From: Matt Bridle <[REDACTED]>
Sent: 05 December [REDACTED]
To: Sian Eggington
Subject: RE: Further Information Required on Your Ref: PP-08311427 Our Ref: BN/120/19/HH

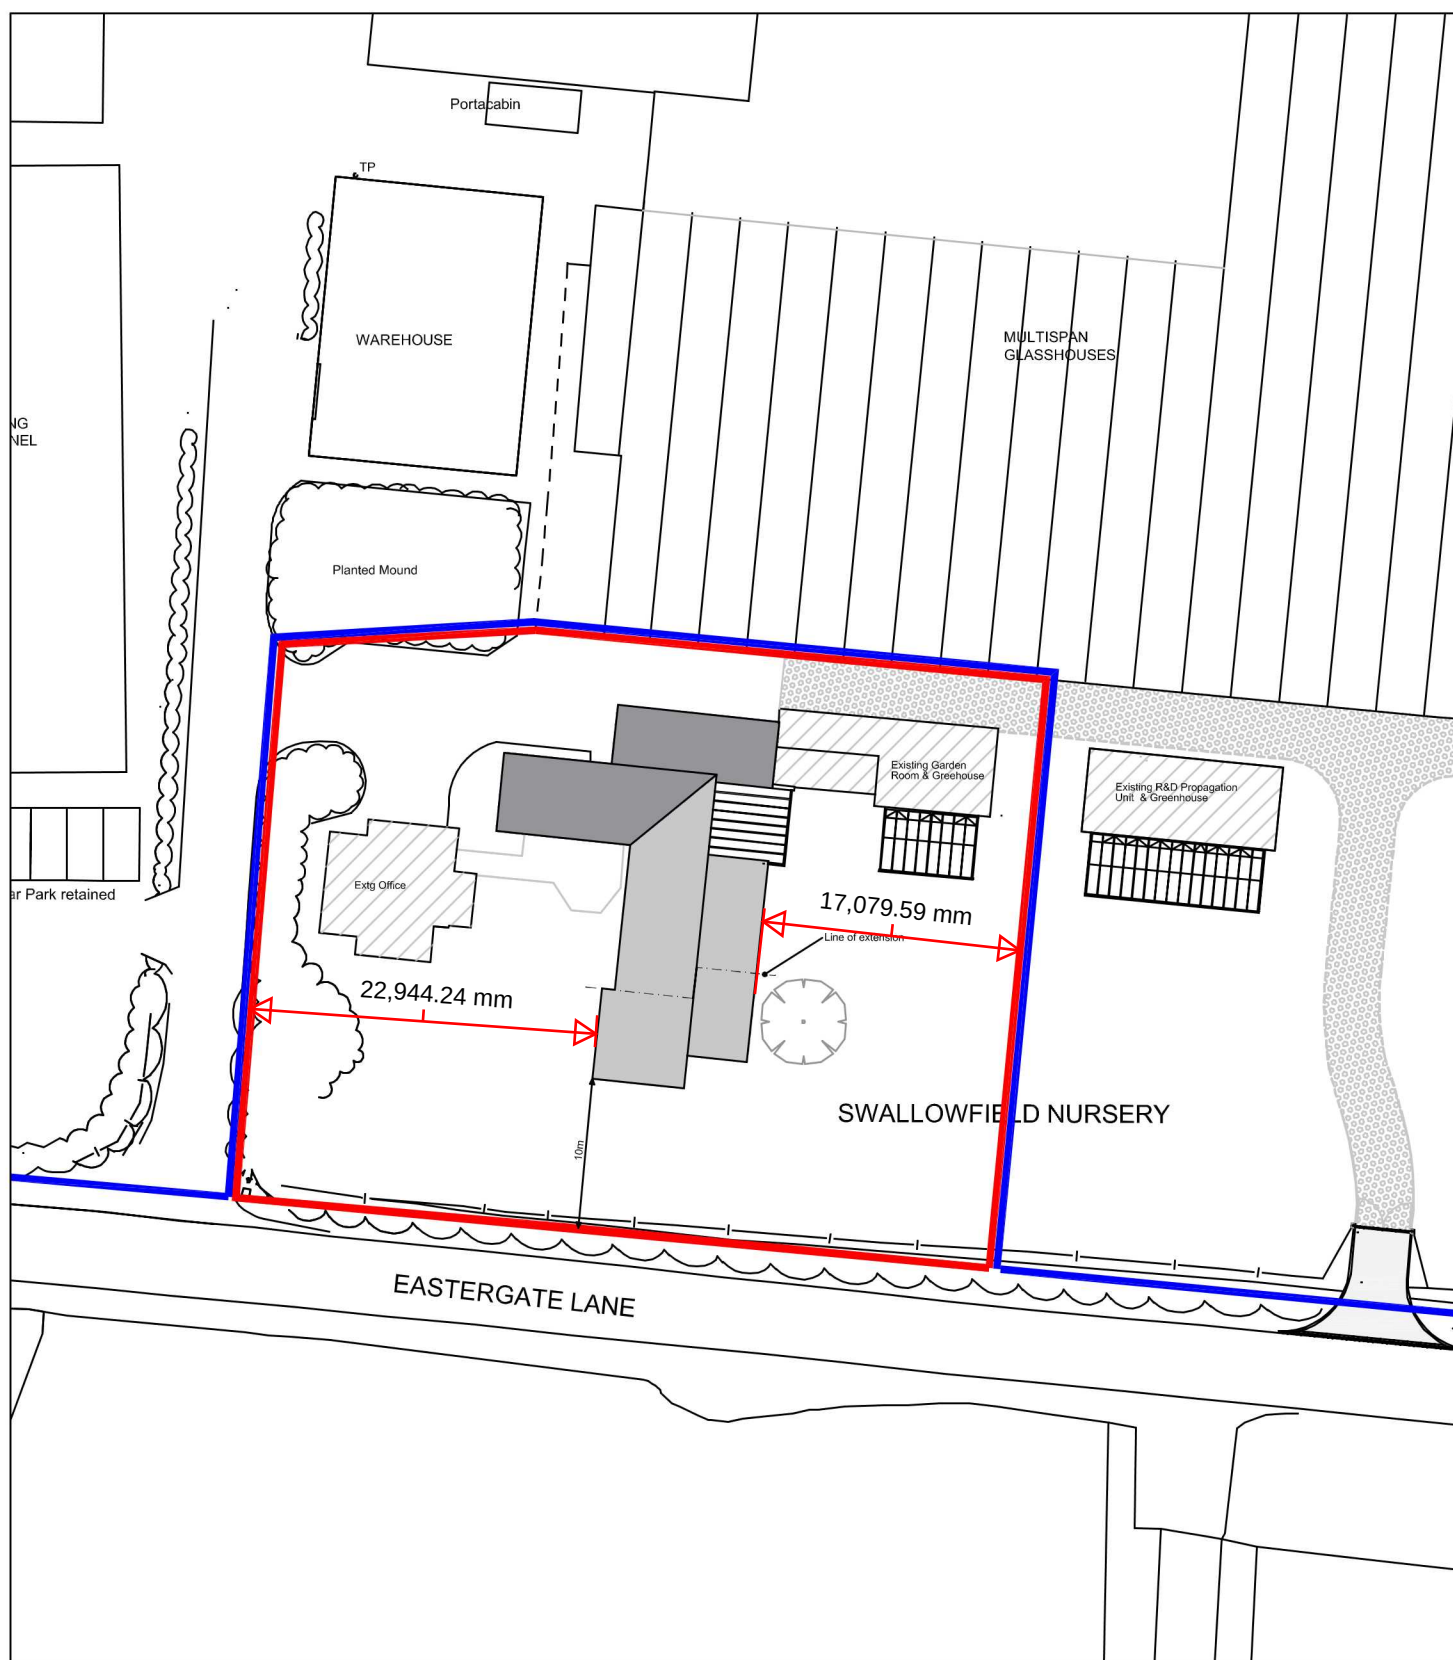
Dimensions are required to the side boundaries as well. With your permission we can add these for you.

Not really sure on the relevance of it but what boundary are you referring to, the notional red edge of the site or the property ownership in blue?
Happy for you to amend.
